Application No: EP/60/21/HH
Site Address: New Lodge Seaview Road East Preston BN16 1LX
Description of works: Erection of two side dormers

This council's Planning & Licensing Committee considered this Application at its meetings on Monday 28th June and 12th July. The applicant was invited to both meetings and attended the first, sending apologies for the second.

DRWG No: BSB/21/836/2/A

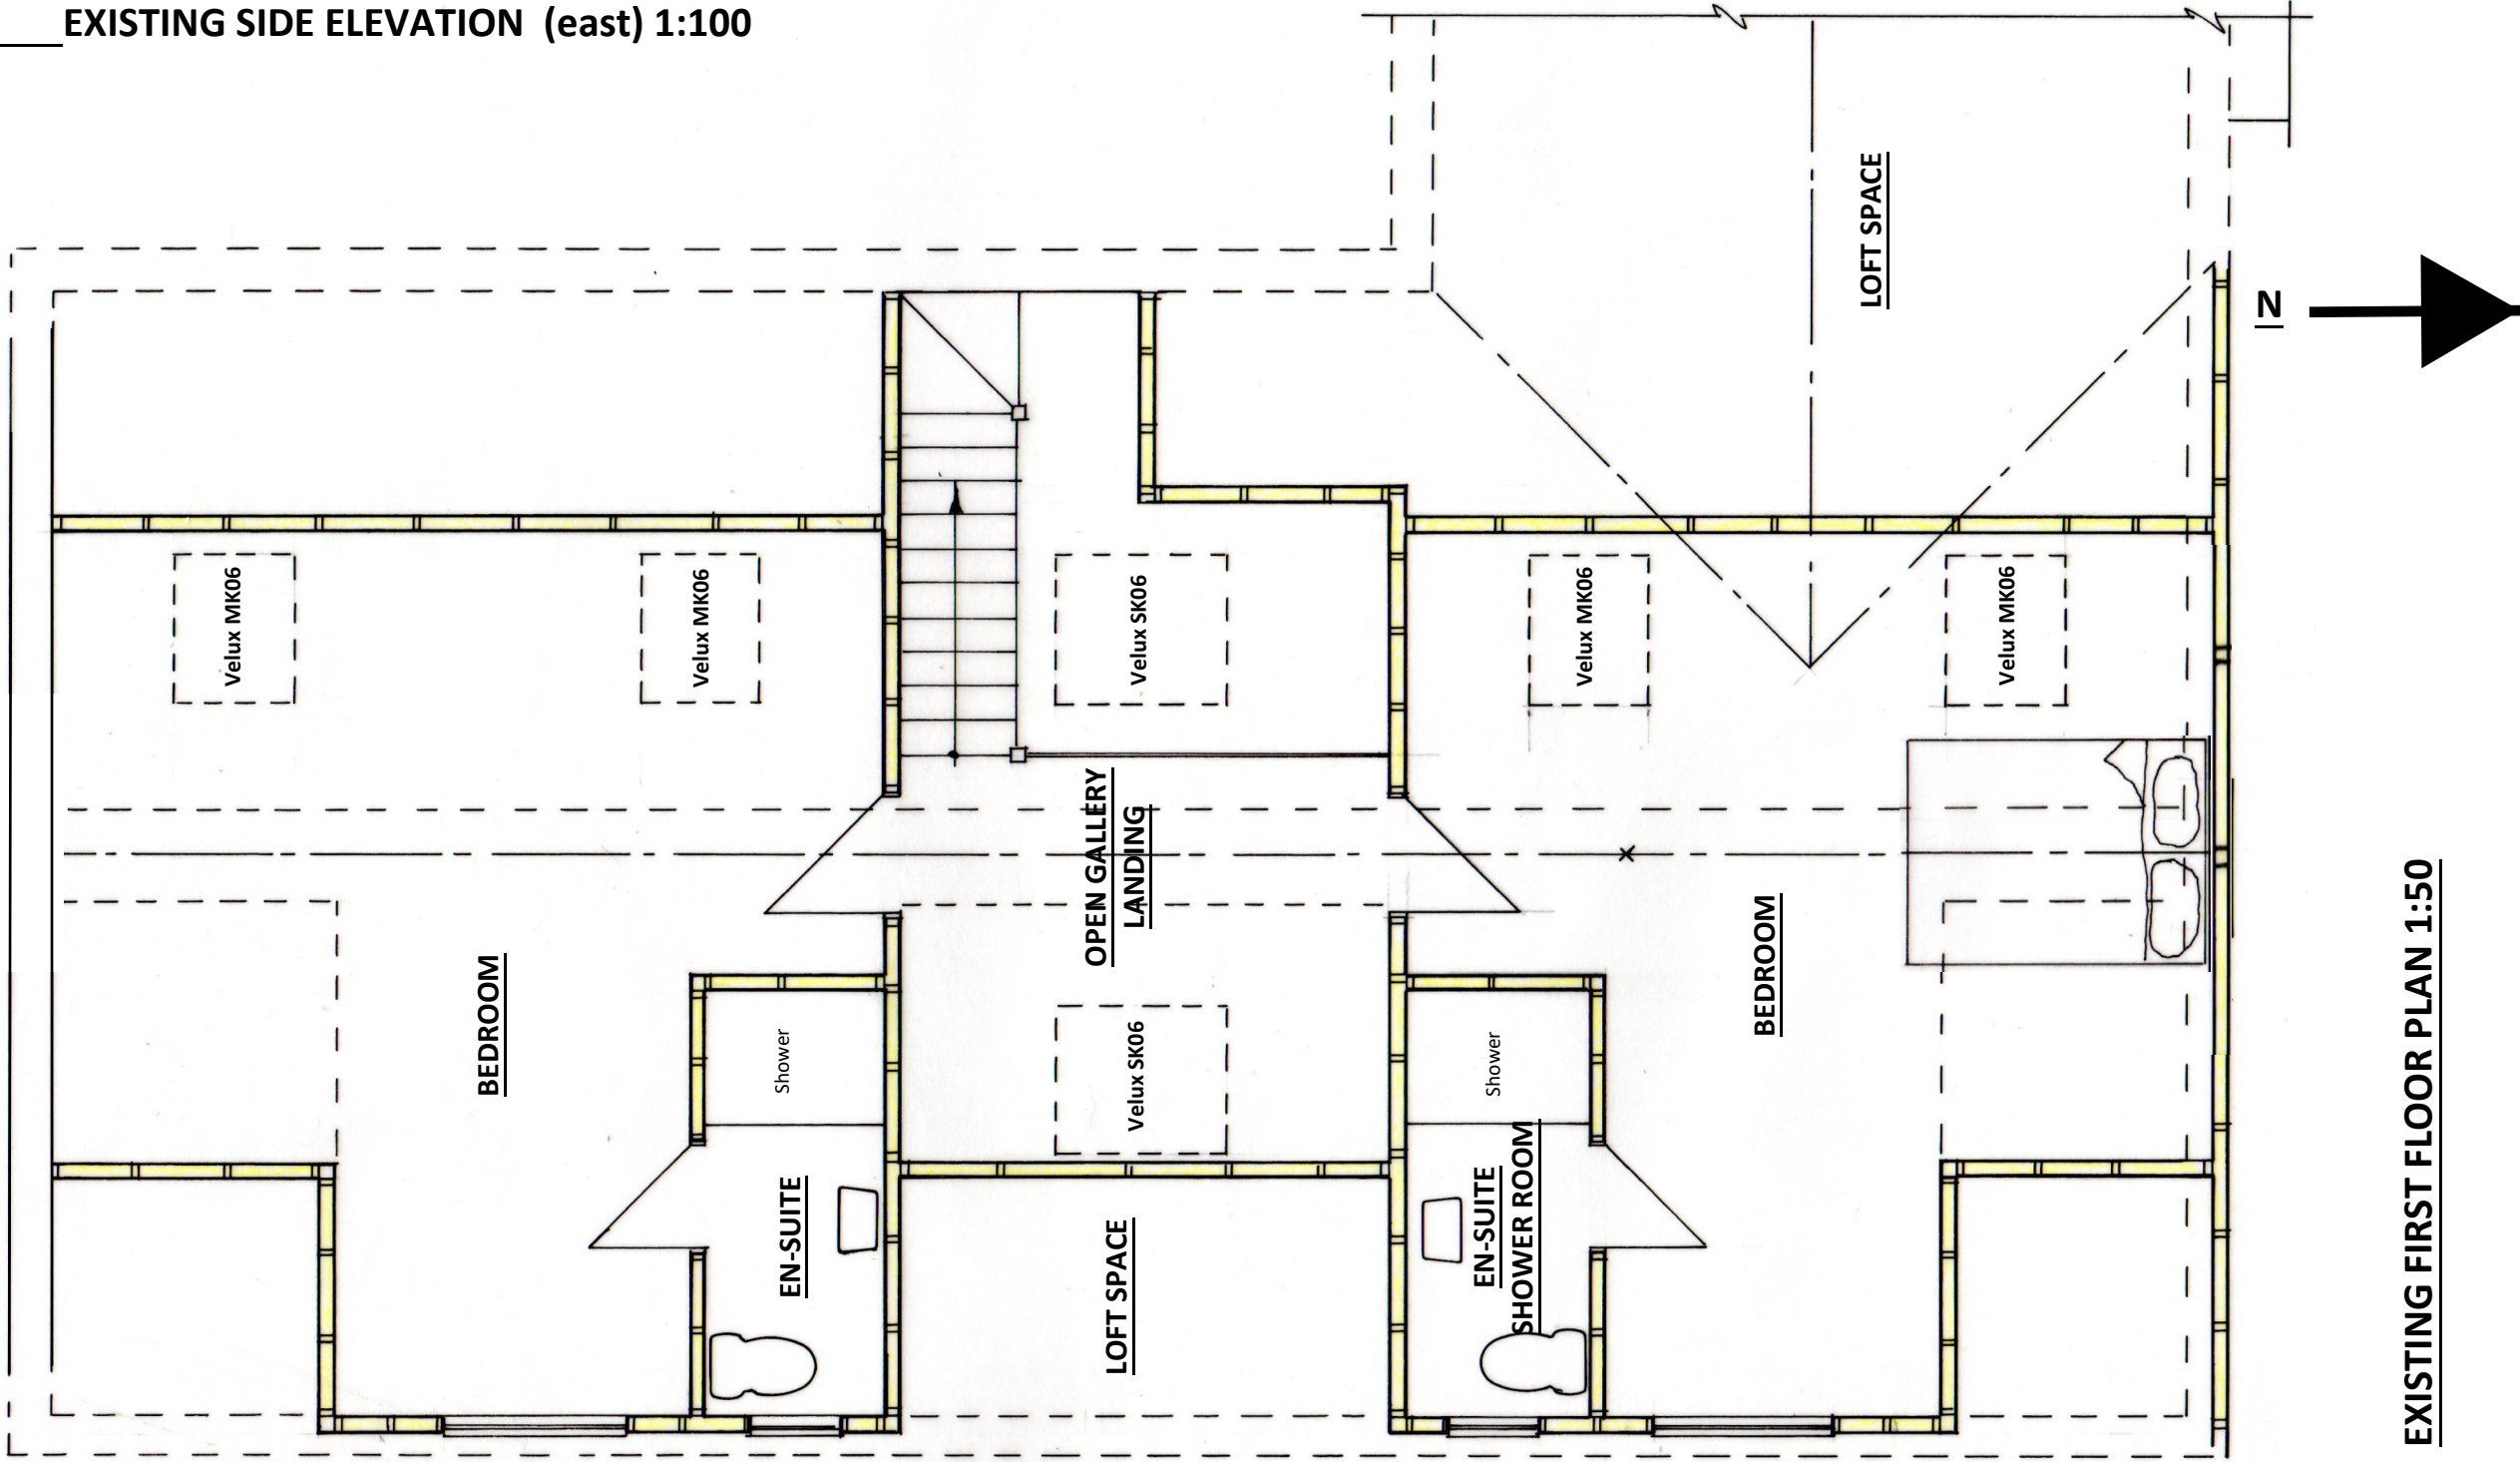
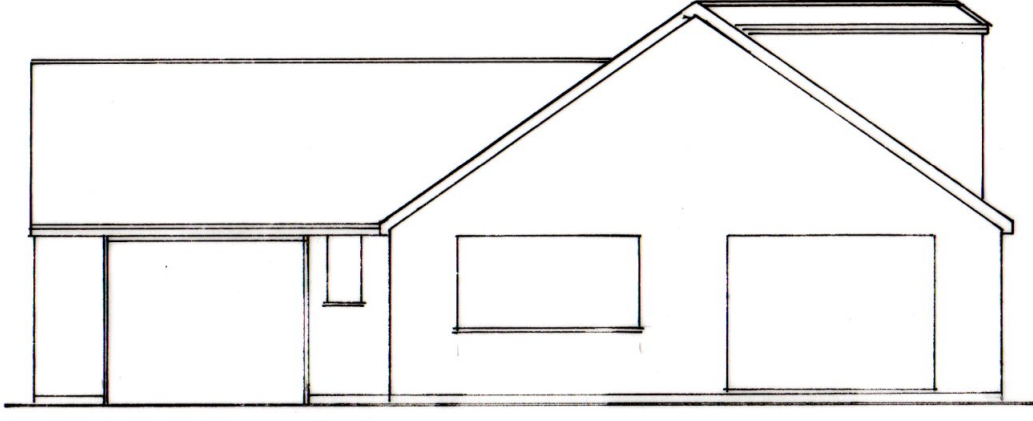
No drawing has been provided showing the proposed south elevation, this being the elevation most visible to members of the public.
